# **Application by Highways England for an Order Granting Development Consent for A57 Link Roads**

## **The Examining Authority's third written questions and requests for information**

### **High Peak Borough Council's Response**

**6.4 Environmental Statement  
Figure 5.4 Air Quality EU Compliance Risk  
Assessment**

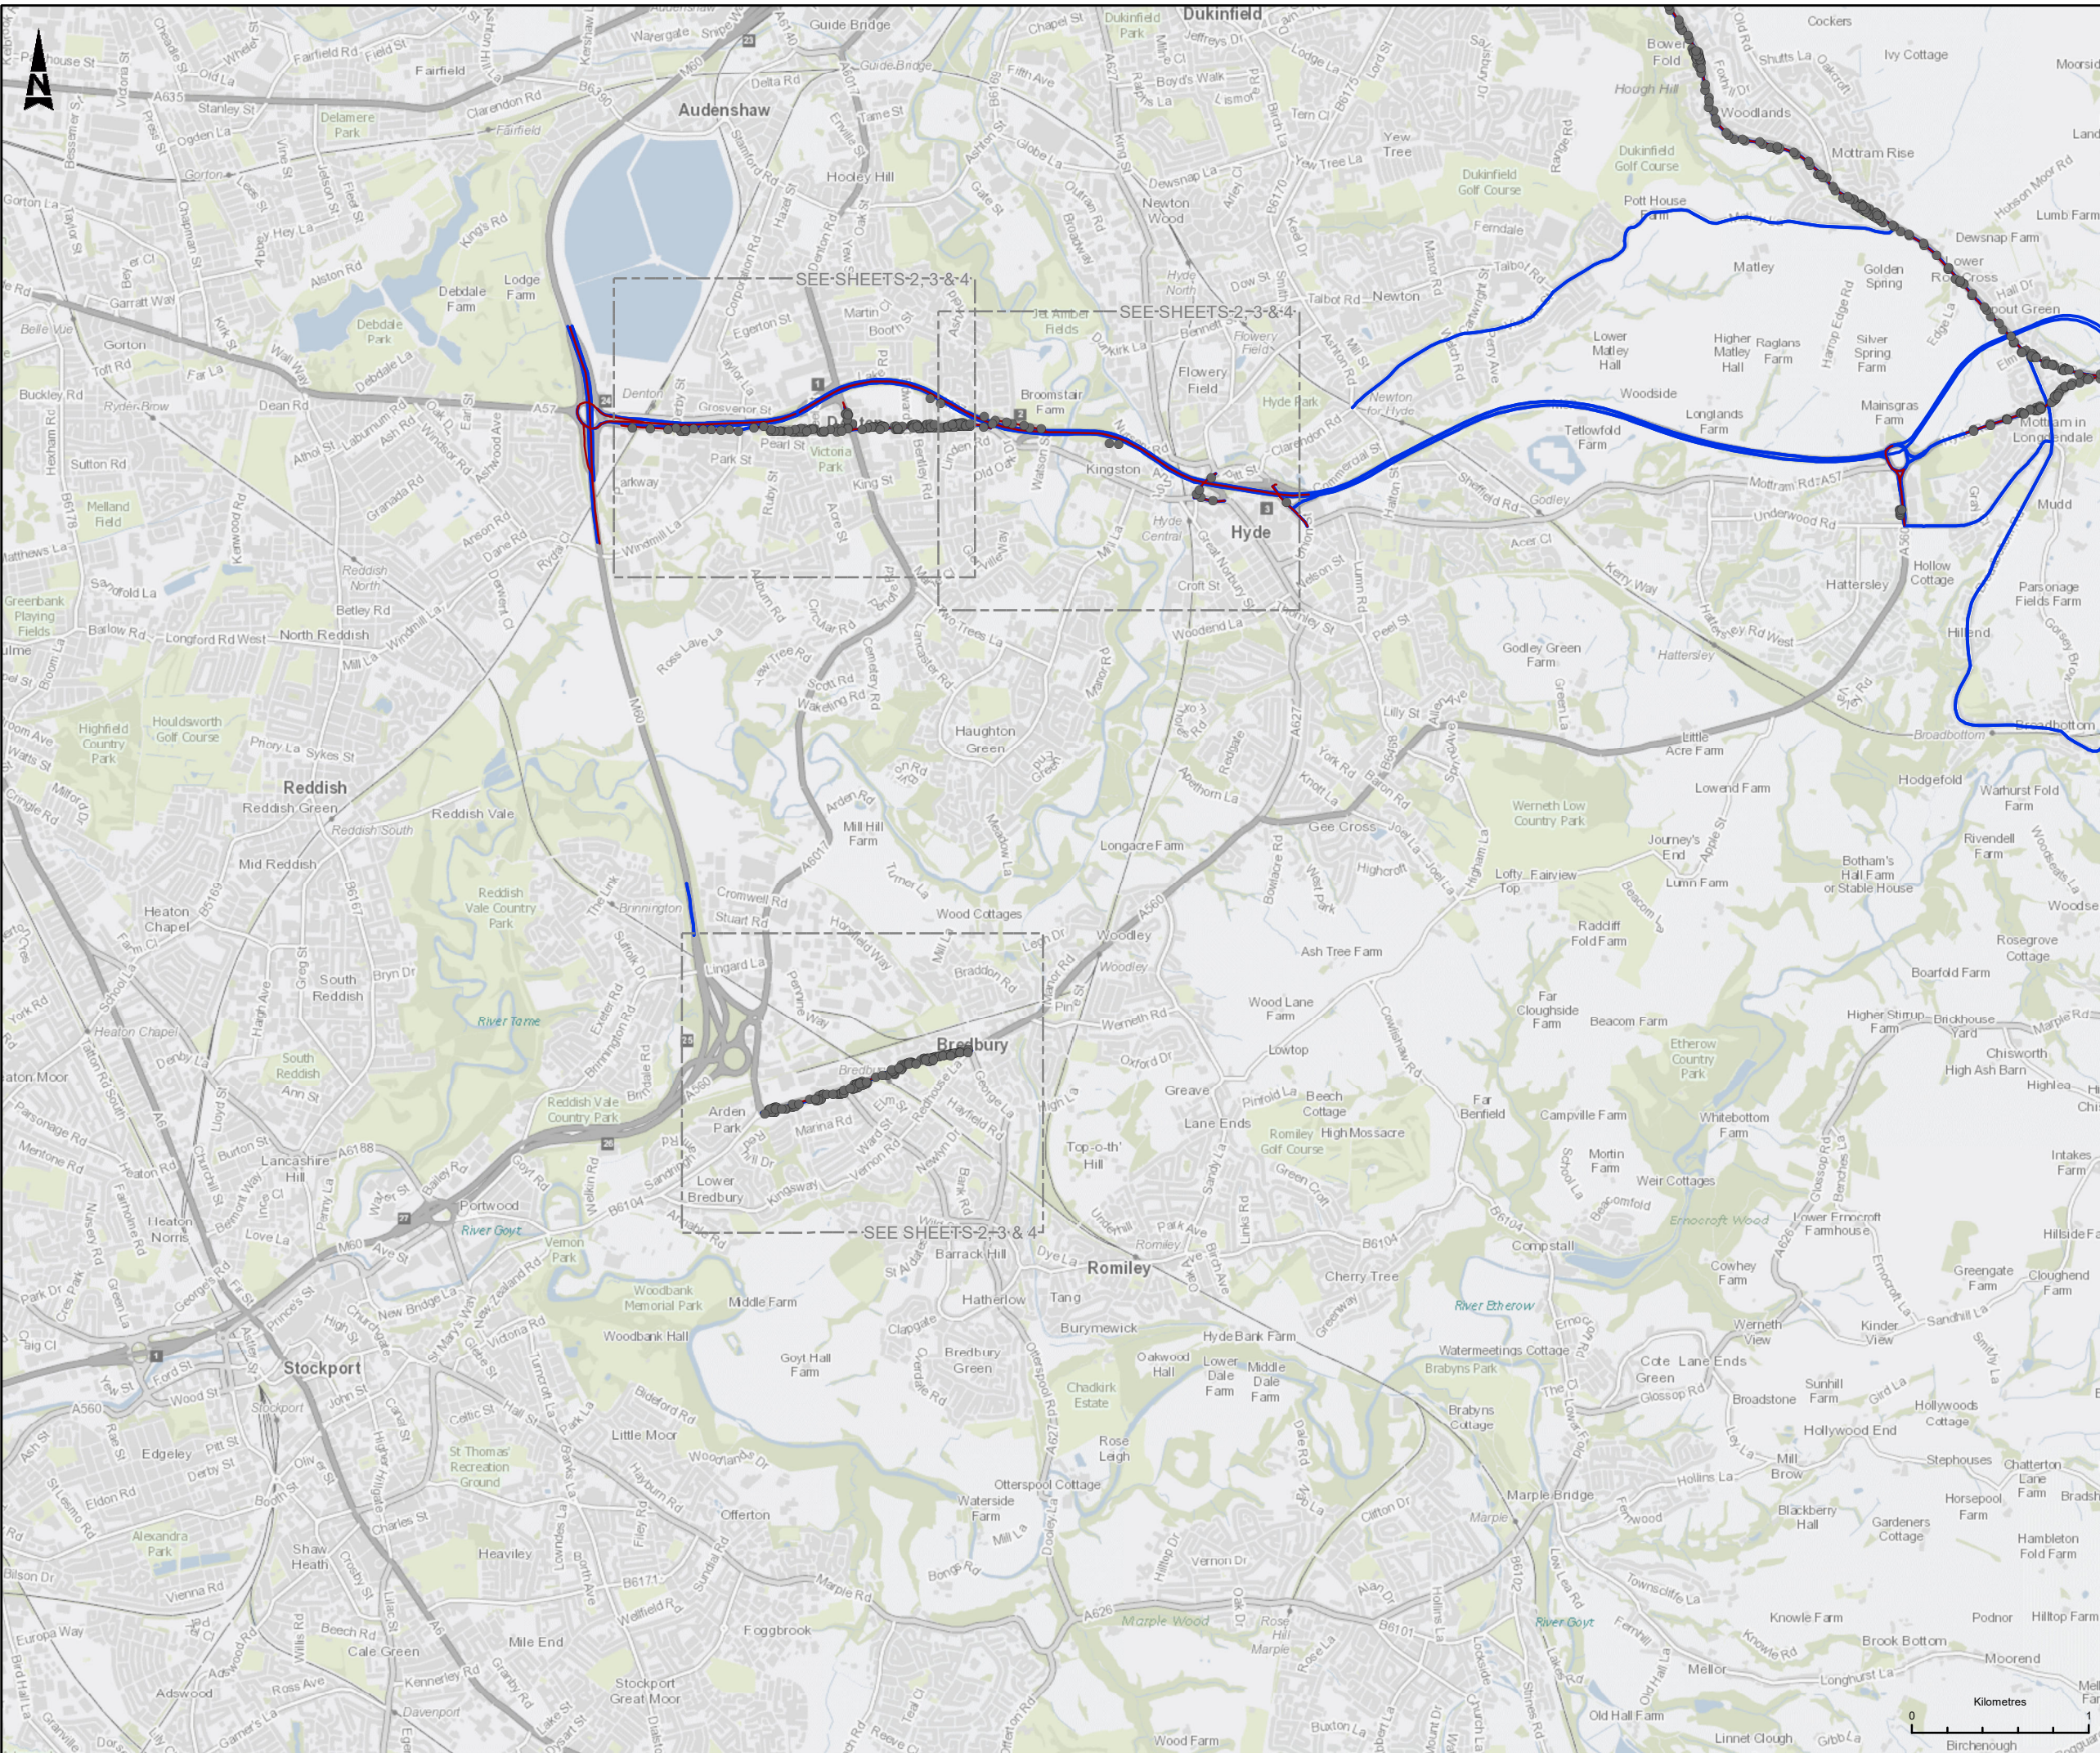
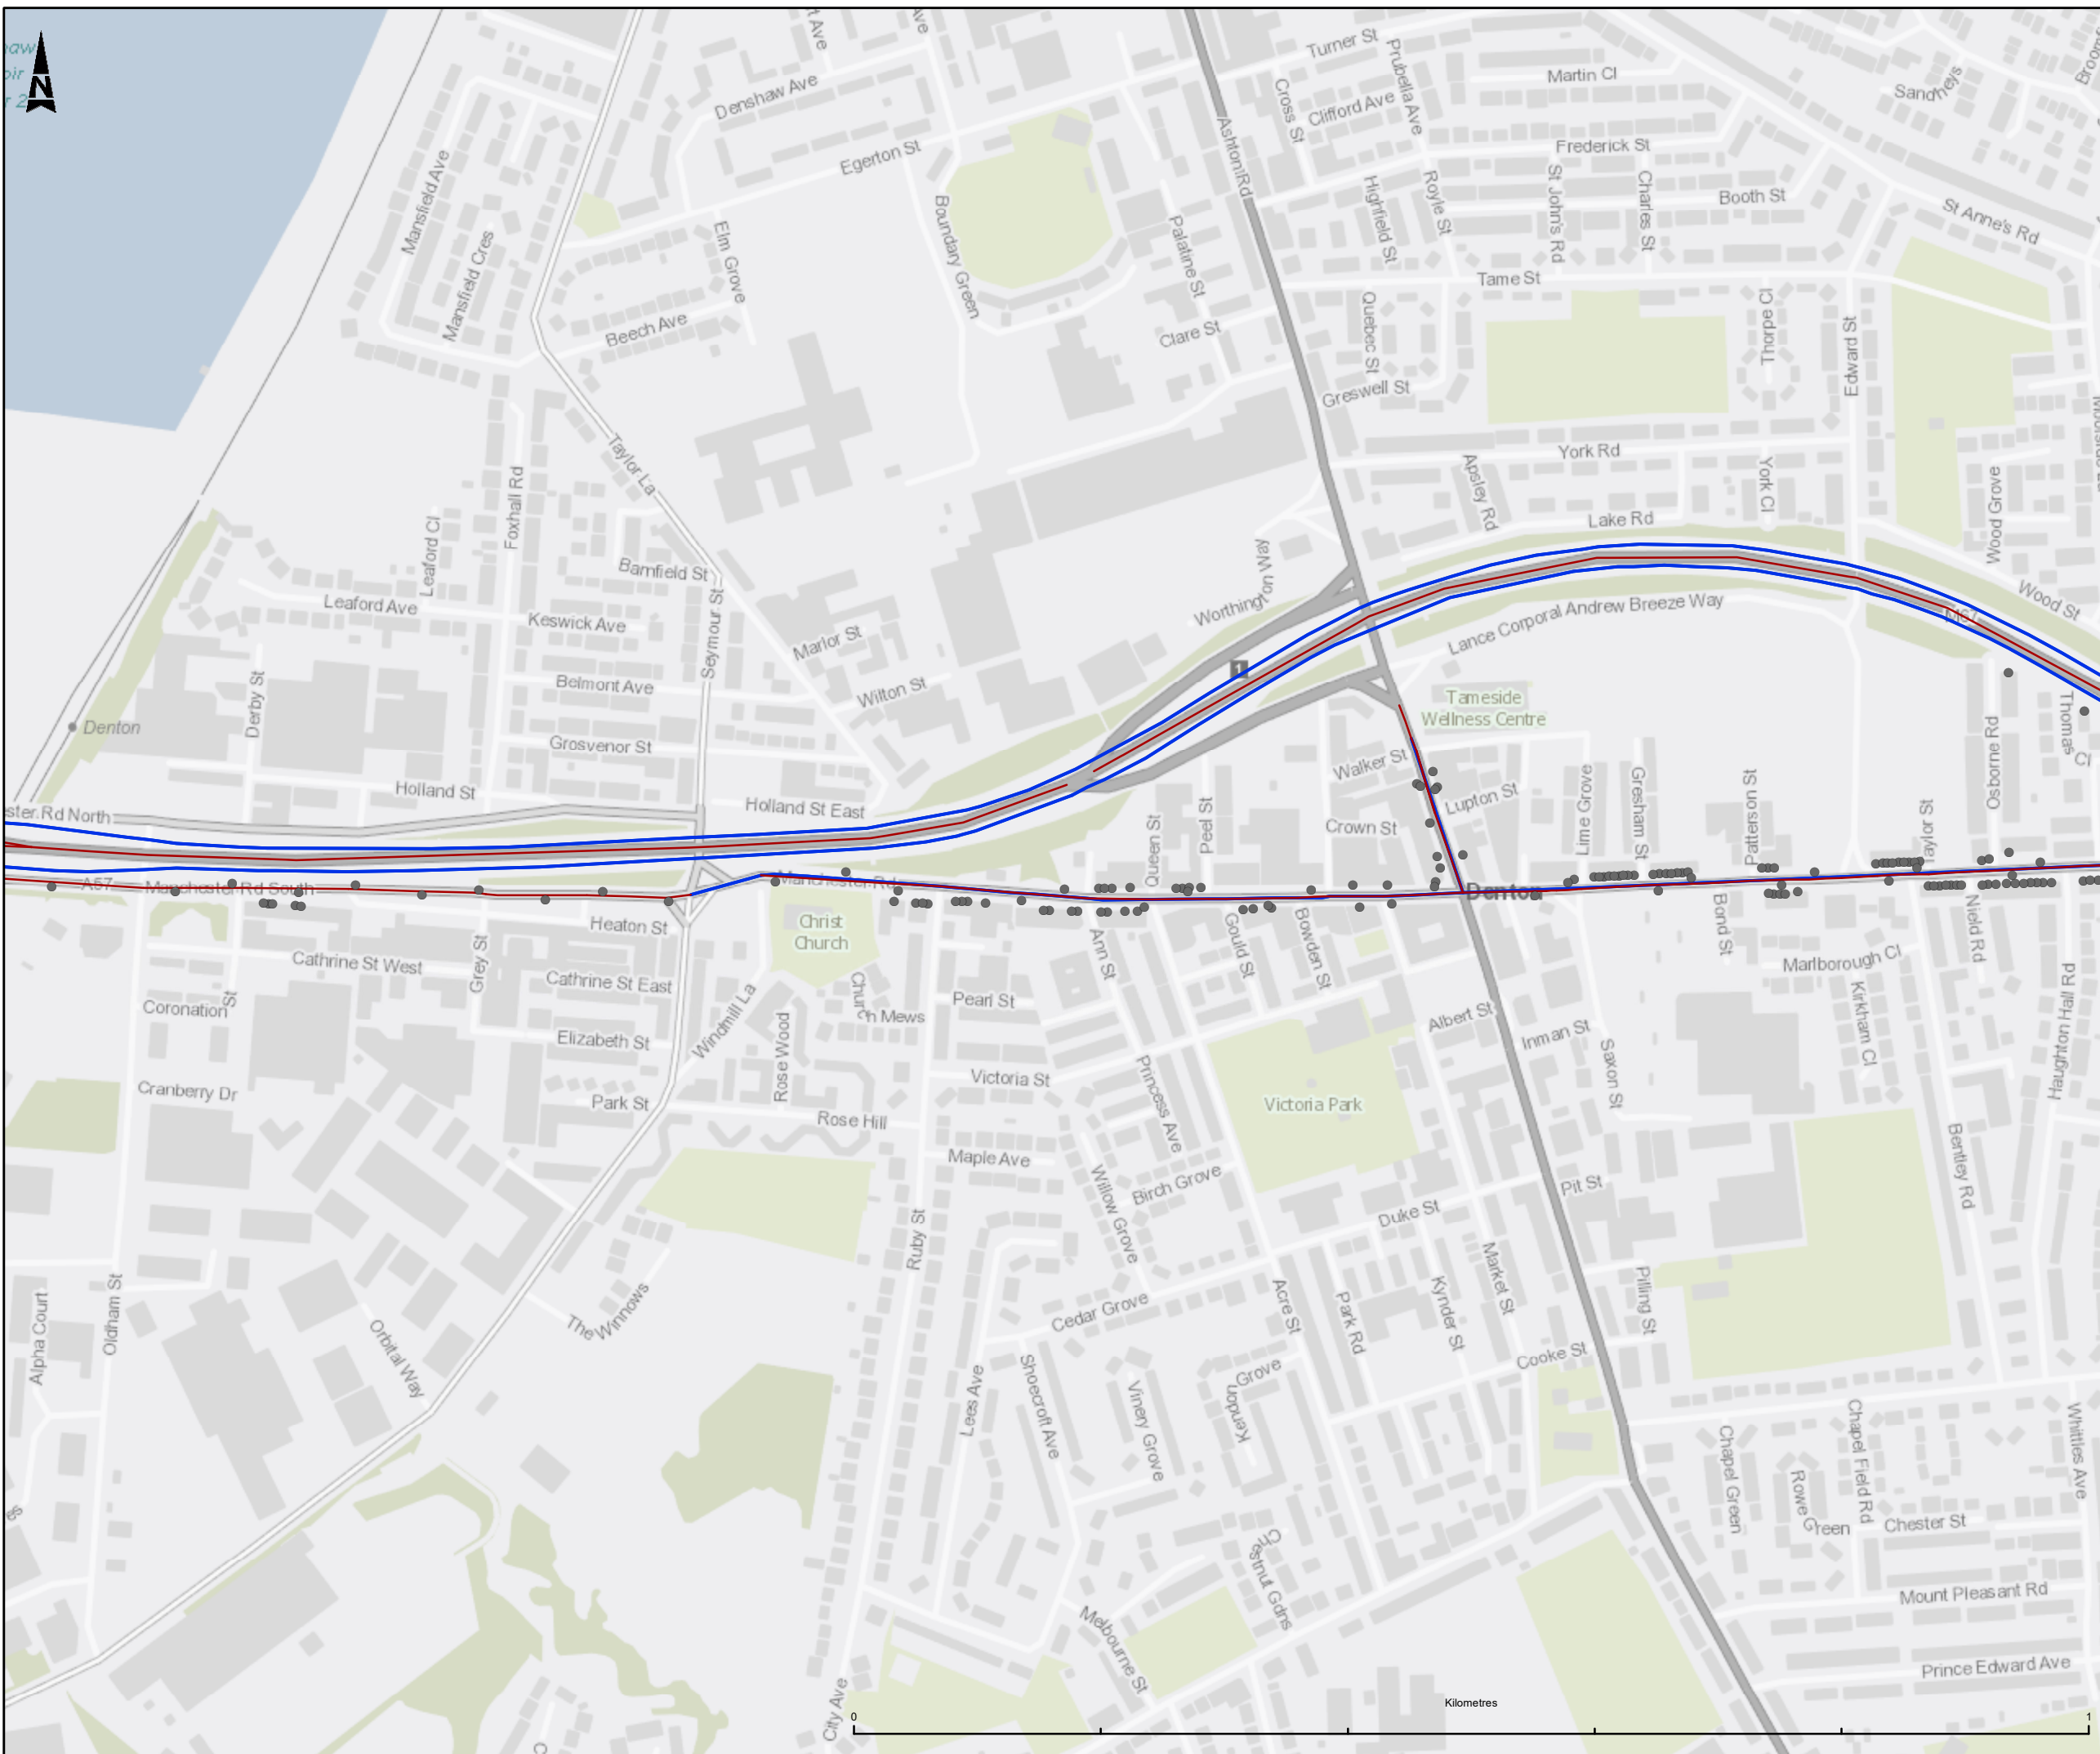
Identification of the receptors (figure 5.4) used in the compliance risk assessment (using LAQM “conservative” forecast”) indicated that “large” change at some of the receptors along Brookfield.

However, it also highlighted that some of these were human health receptors that had not been included as receptors in the (less conservative) primary human health AQ assessment (DMRB LA 105). Therefore, HPBC have requested that these receptors are also assessed in accordance with the DMRB LA 105 . Following further discussion and clarification (virtual meeting held 8th April 2022) it was agreed that a sensitivity test will be undertaken to identify the air quality impact at relevant qualifying feature receptors located adjacent to the A57 Brookfield under the DMRB LA 105 human health assessment methodology (to be submitted by National Highways at deadline 11 – ref. TR010034/EXAM/9.86)

Results from the updated air quality assessment updated DMRB LA 105 indicated a “Large increase” in NO<sub>2</sub> DS compared to DM in 2025, at locations along Wooley Bridge with 1 location exceeding the AQO (40ug/m<sup>3</sup>) as a result of the scheme.
